has permission to Build New 2,150 sq. Ft. Single Family Home

AT 0 Rivers Edge Dr. Lot # 20 ... 217 B050001

Permit No: 03-1405	Issue Date: 11/12/2003	CBL: 217 B050001
-----------------------	---------------------------	---------------------

TO: Inspections Department
FROM: Jay Reynolds, Development Review Coordinator
DATE: July 2, 2004
RE: C. of O. for #93 River's Edge Drive
(CBL 217B050) (ID 2003-0237)

**FOUNDATION PLAN**

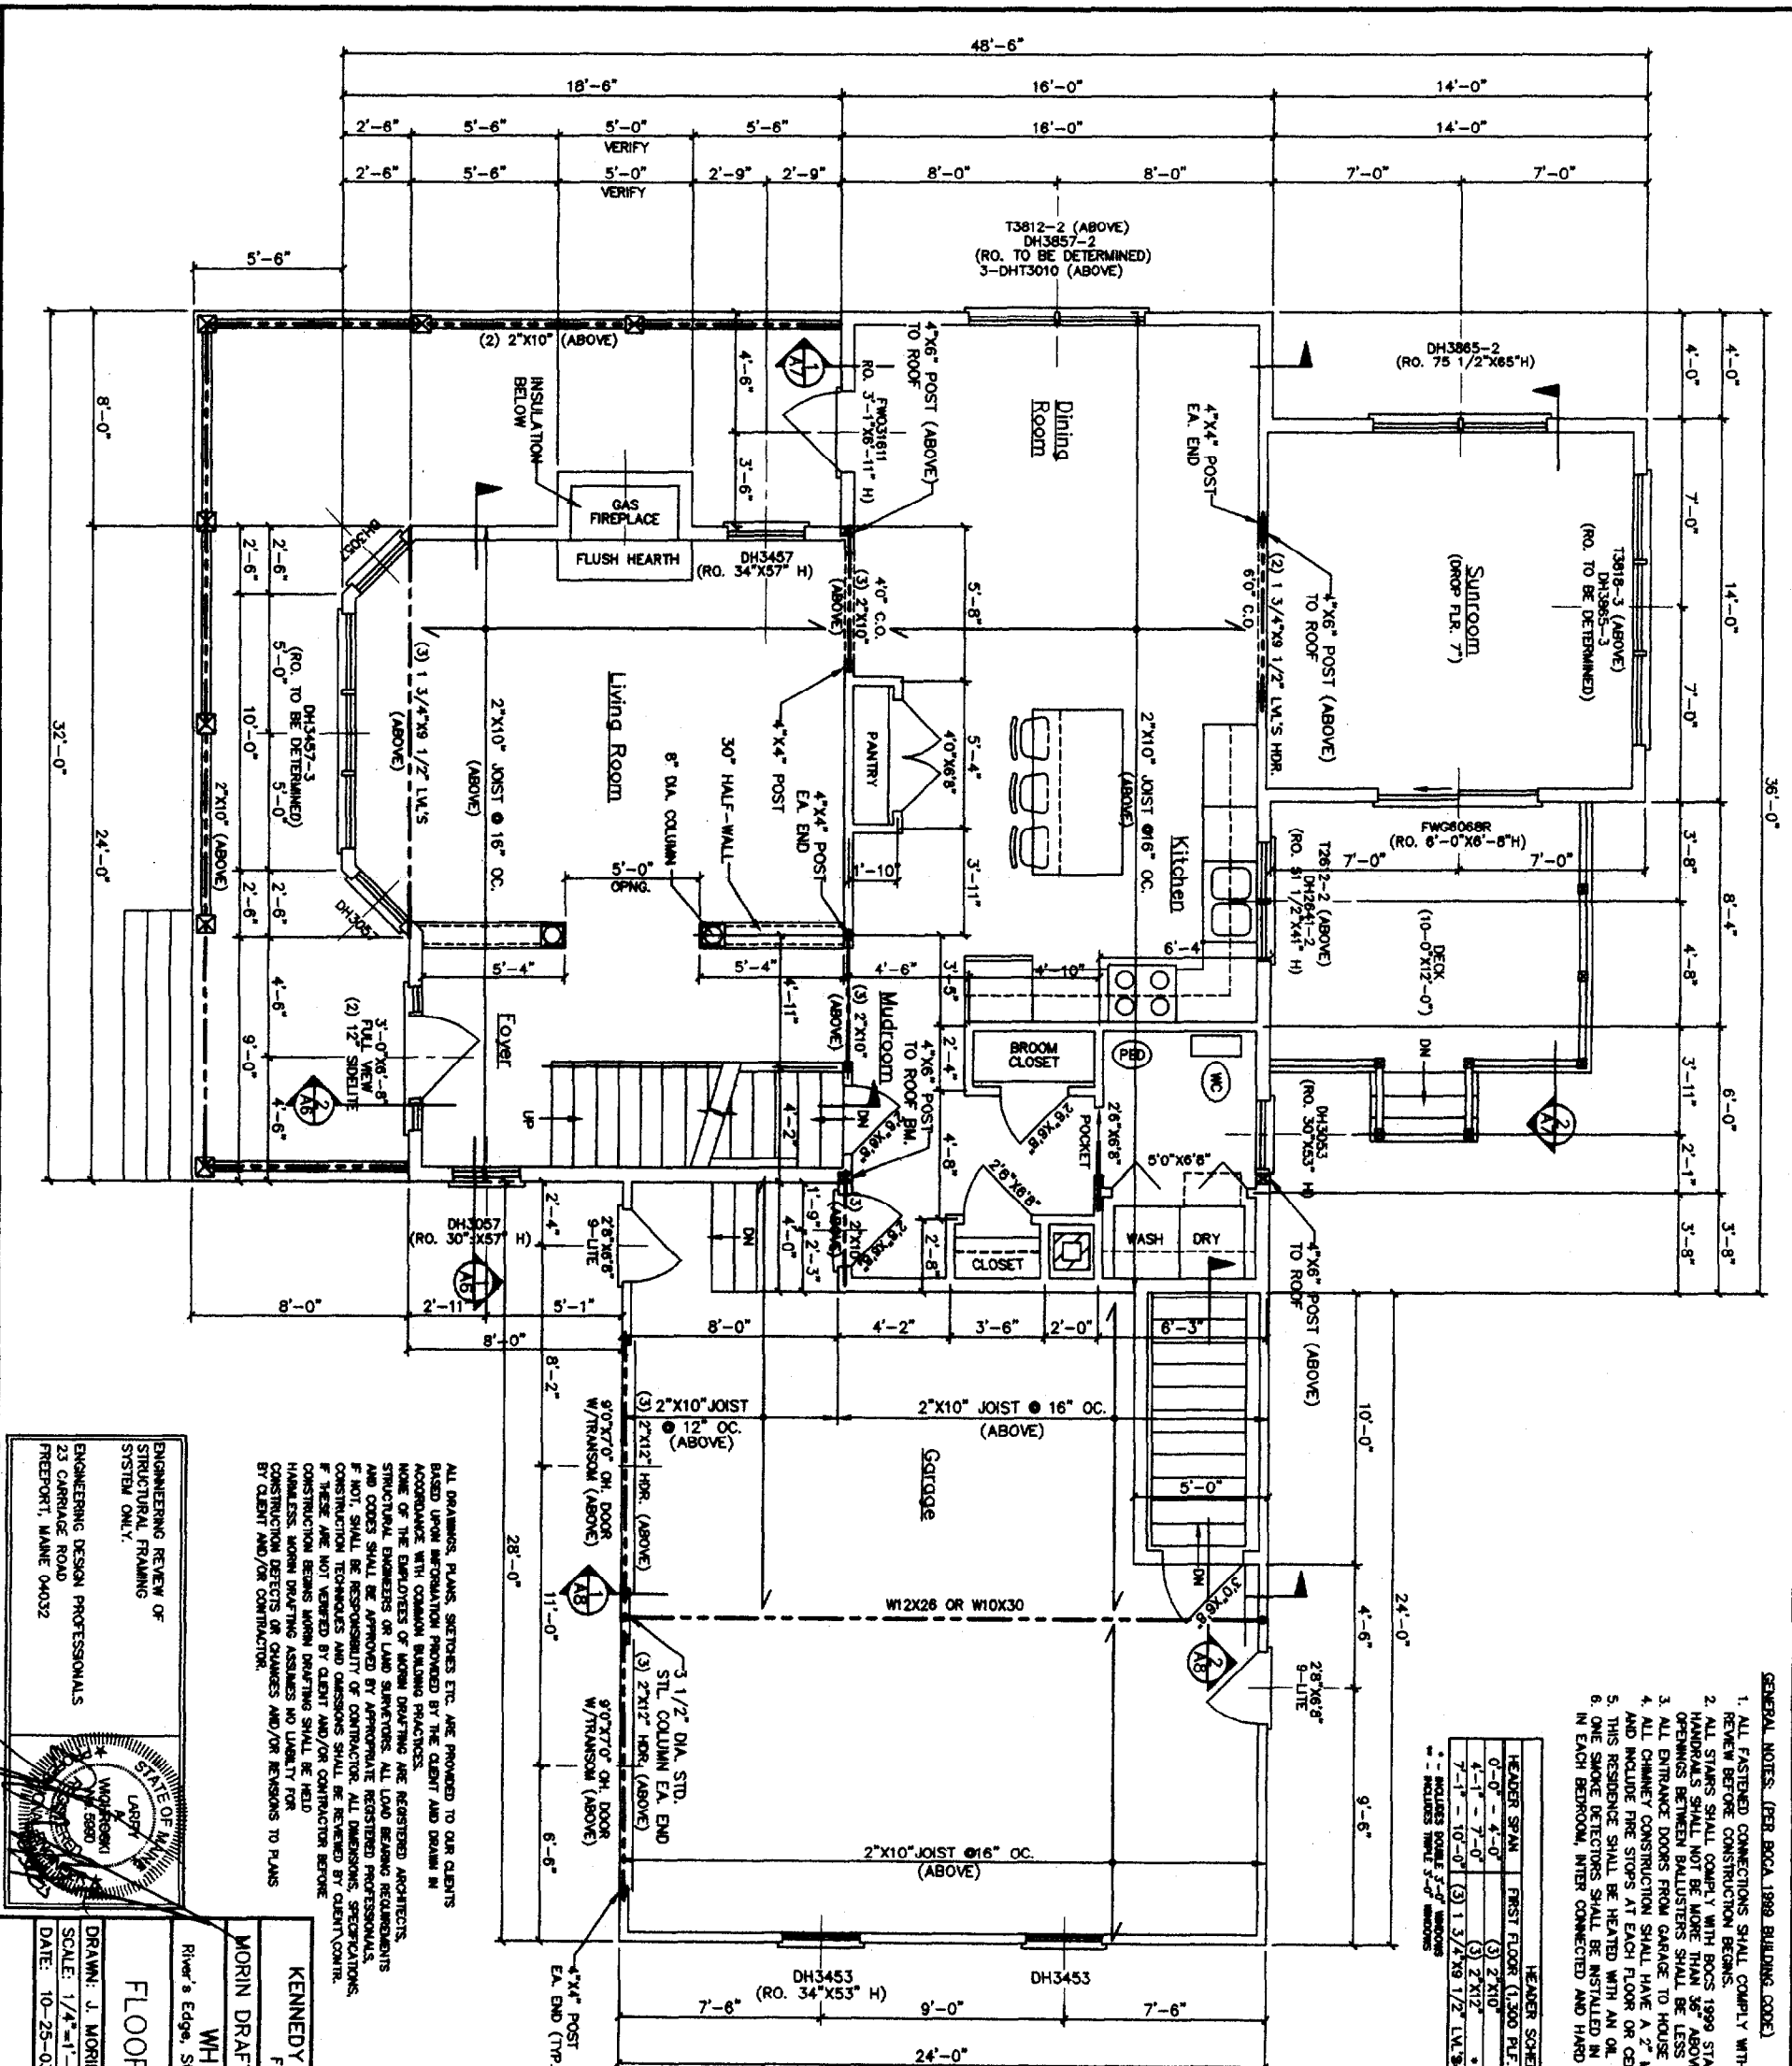
- 1) No daylight basements are being shown. No daylight basements are being approved.
- 2) Separate permits shall be required for future decks, sheds, pools, and/or garages. Presently you are being approved for a 10'x12' rear deck and a 8'x32' front porch.
- 3) This permit is being approved on the basis of plans submitted. Any deviations shall require a separate approval before starting that work.

**FLOOR PLAN - 1ST FLR.**

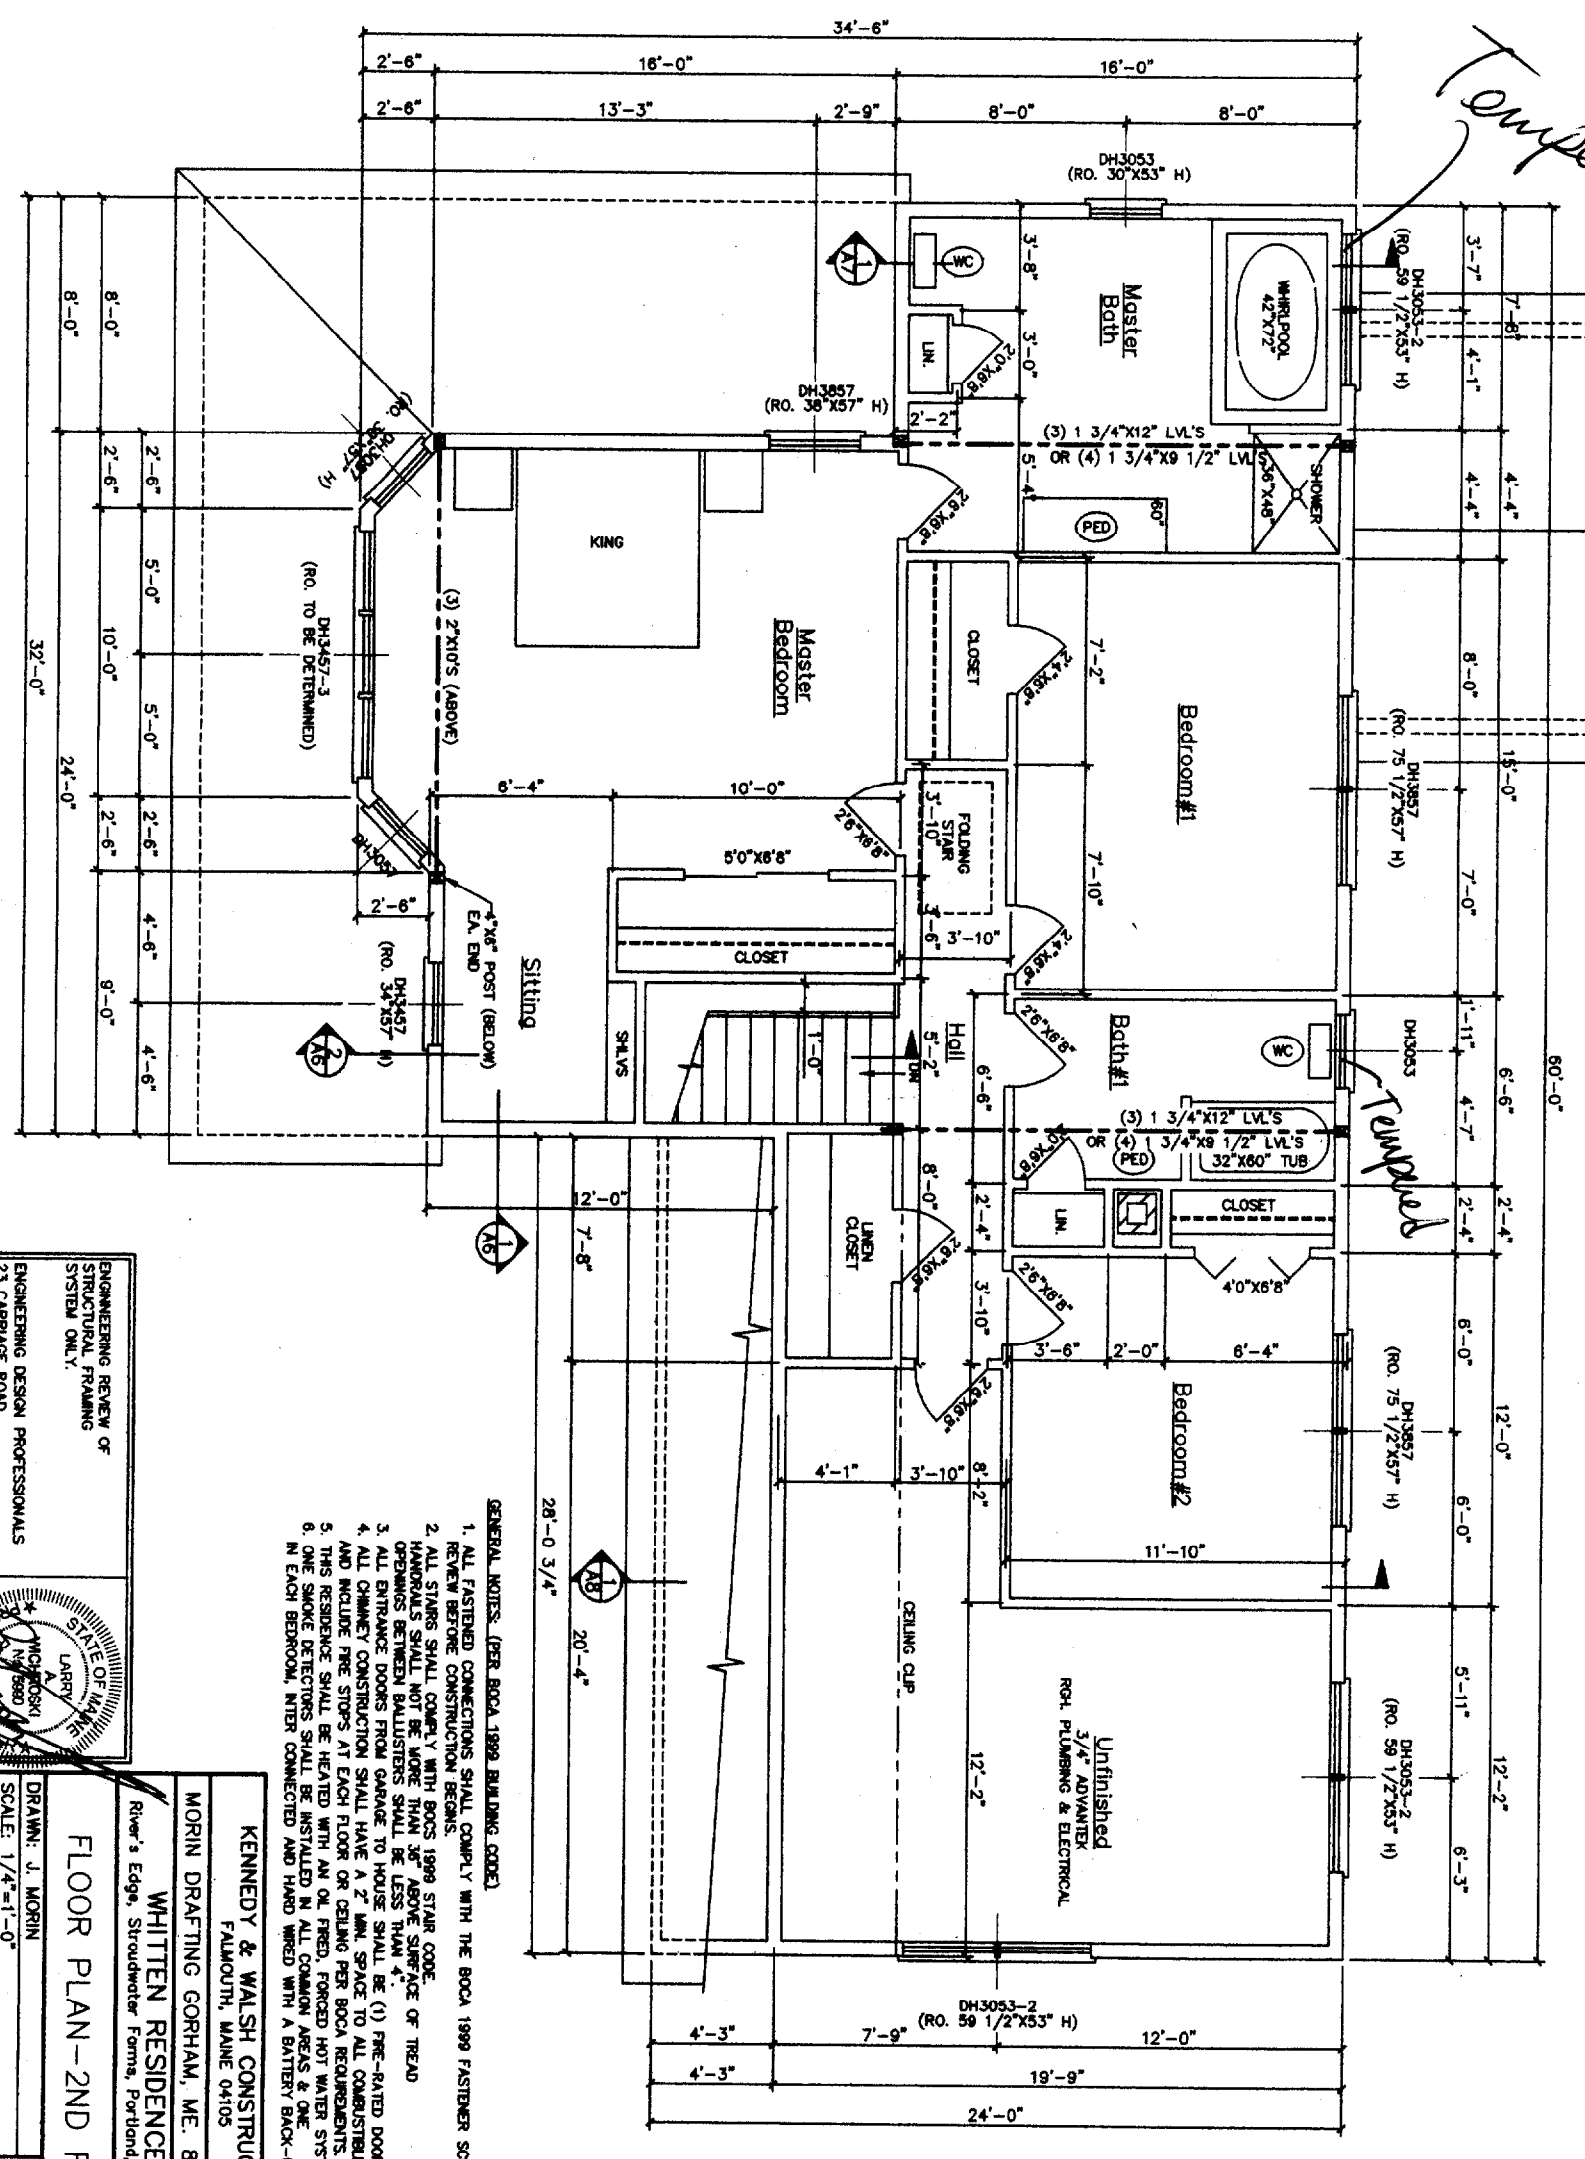
Dept: Building **Status:** Approved with Conditions **Reviewer:** Jeanine Bourke **Approval Date:** 12/04/2003
Note: 11/24/03 left vm w/ Morin Drafting about to call about plans **Ok to Issue:**
 11/25 called back, discussed carrying beam spans and point load. The engineer is on vacation until next week.
 Left vm w/Bryan K. To call about review update.

- 1) The engineer is on vacation, so a clarification on the carrying beam spans and point load is not available. Prior to any framing, a discussion and verification of the calculations must be submitted and approved.
- 2) Separate permits are required for any electrical or plumbing work.
